PLAN EXAMINATION CONDITIONAL APPROVAL

PROJECT/SITE DESCRIPTION:
Maine Medical – Visitor’s Garage Extension

PROJECT ADDRESS:
22 Bramhall St – Portland, Maine

Review Type:	All Trades
Plans Date:	3/30/18
# of Sheets:	96
Project Area (sq. ft.):	82,201

Drawing file: 01 General / G02-01 - CODE COMPLIANCE ELEVATIONS.pdf

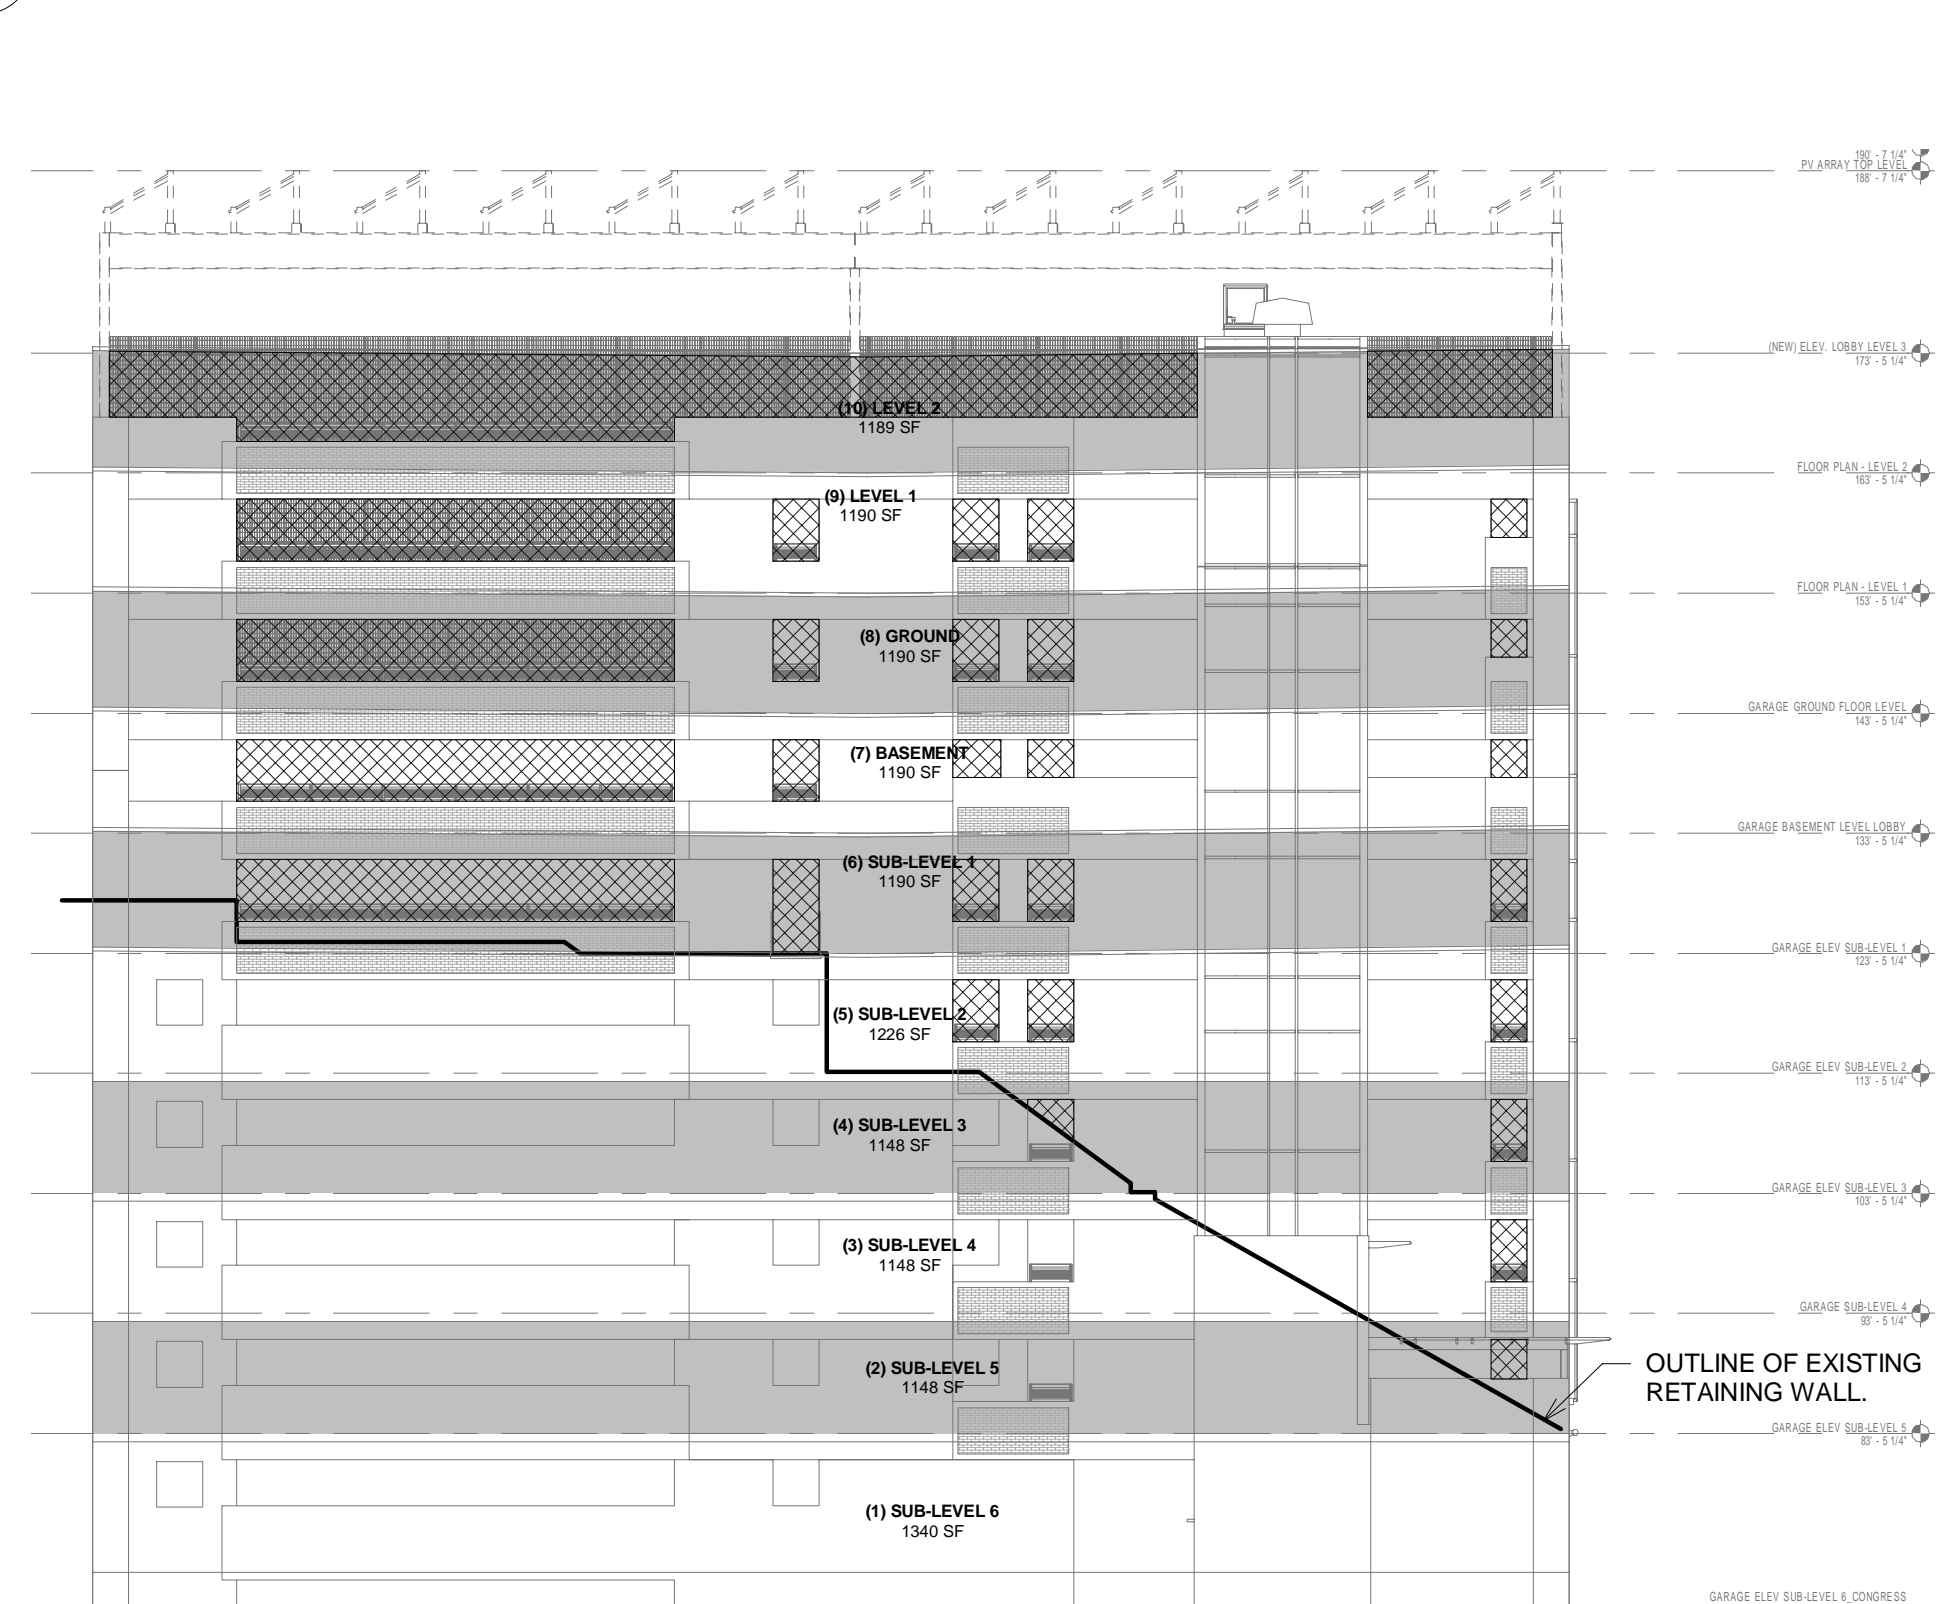
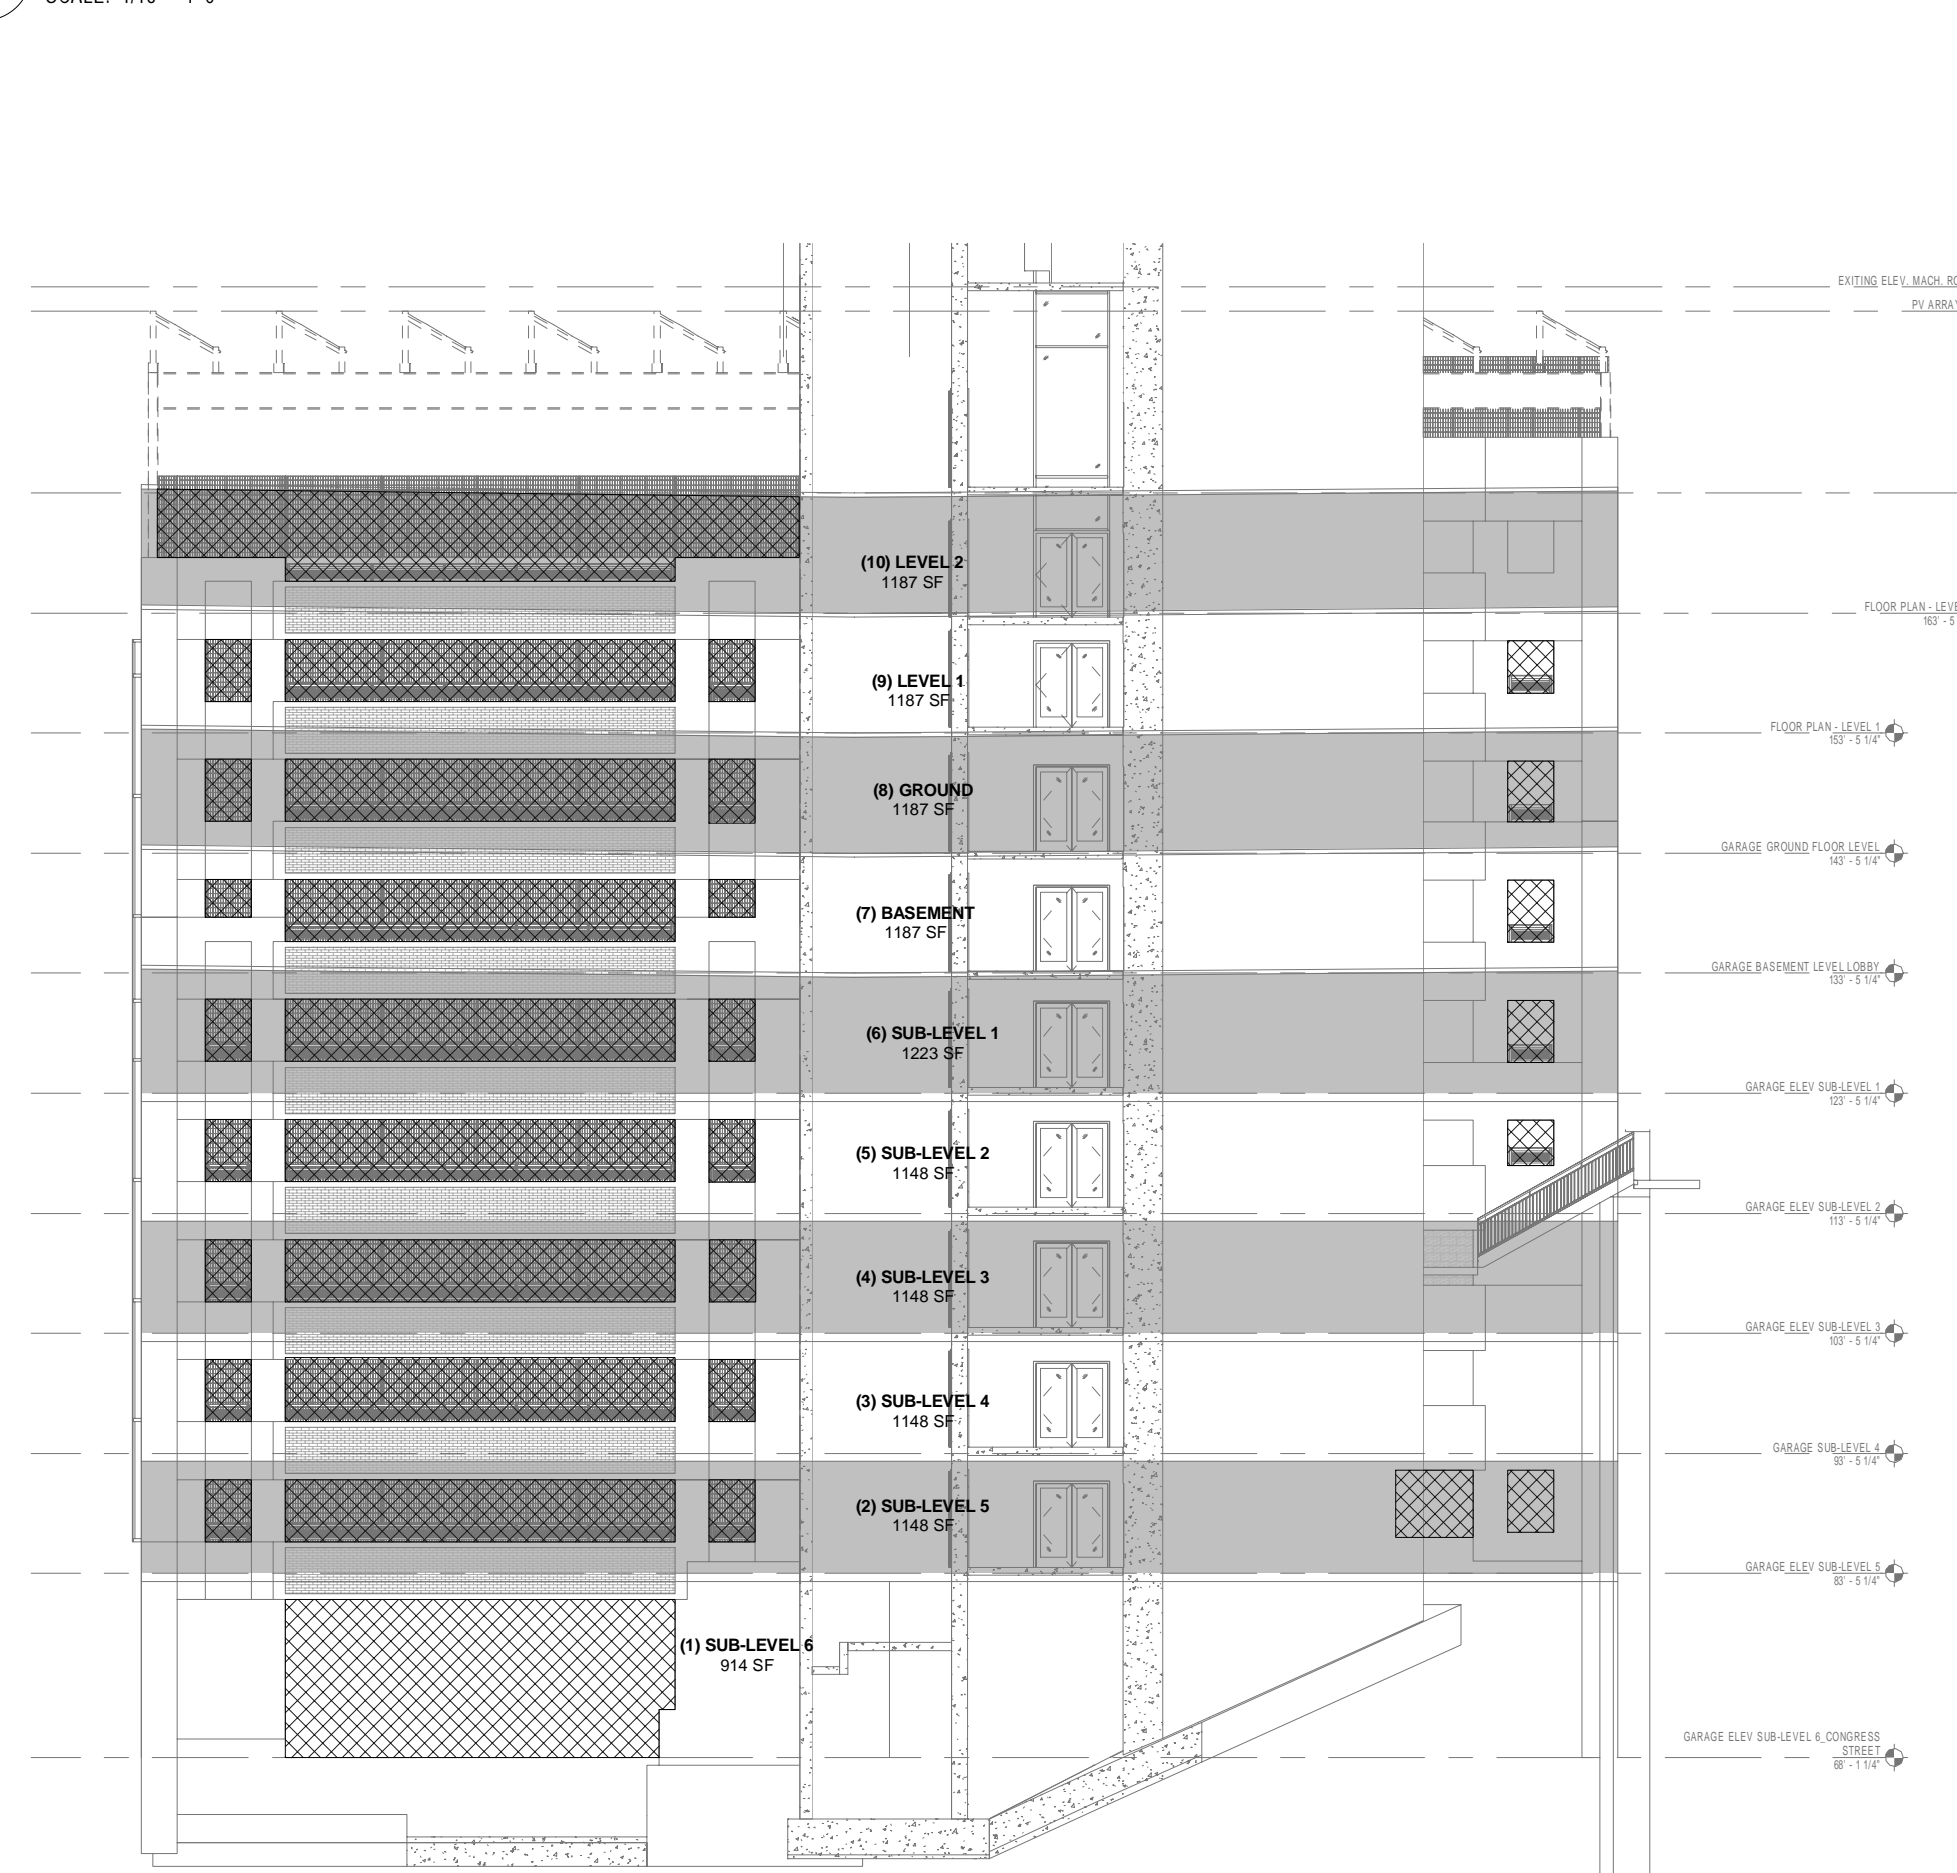
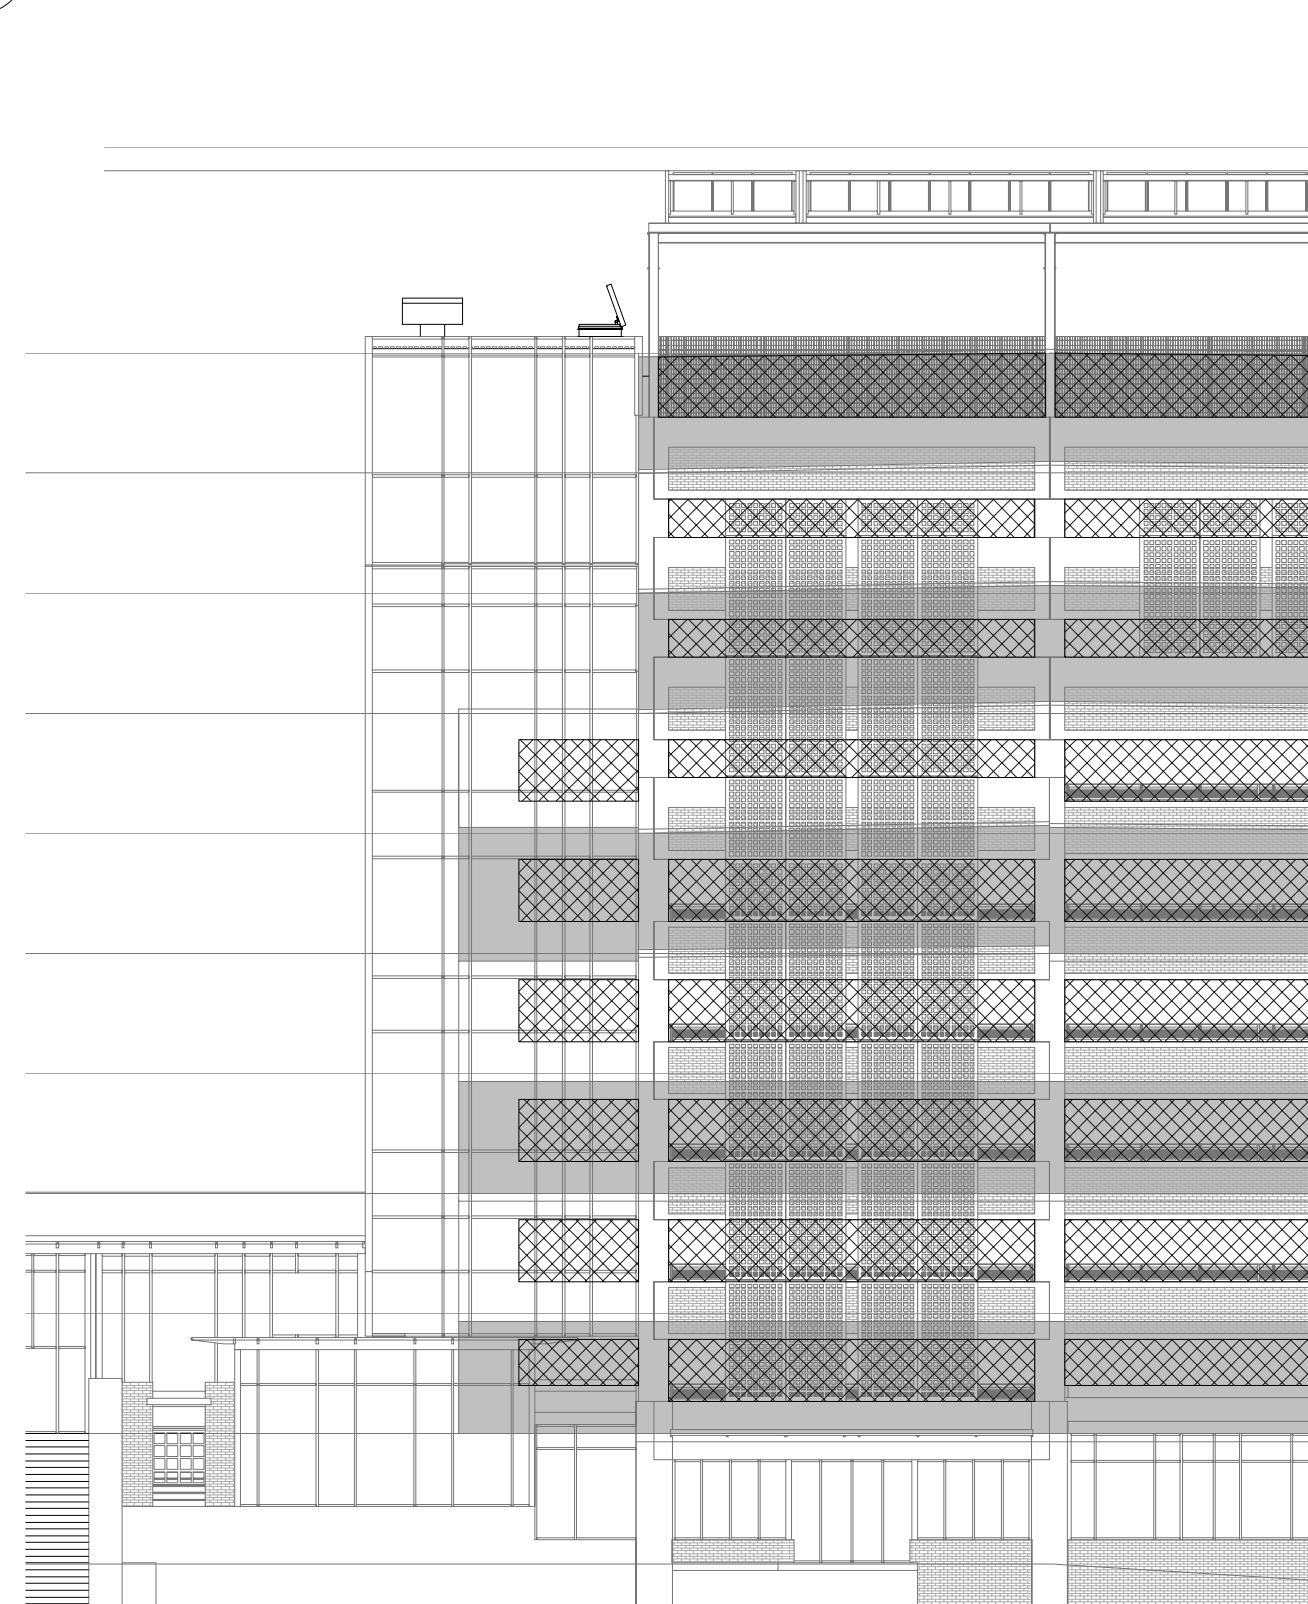
Plan Review Comments are based upon updated G02-01 Code Compliance Elevations sheets provided during review 3/27/18 demonstrating ventilation requirements meeting code requirements to allow for structure to be considered as an "Open Parking Structure".
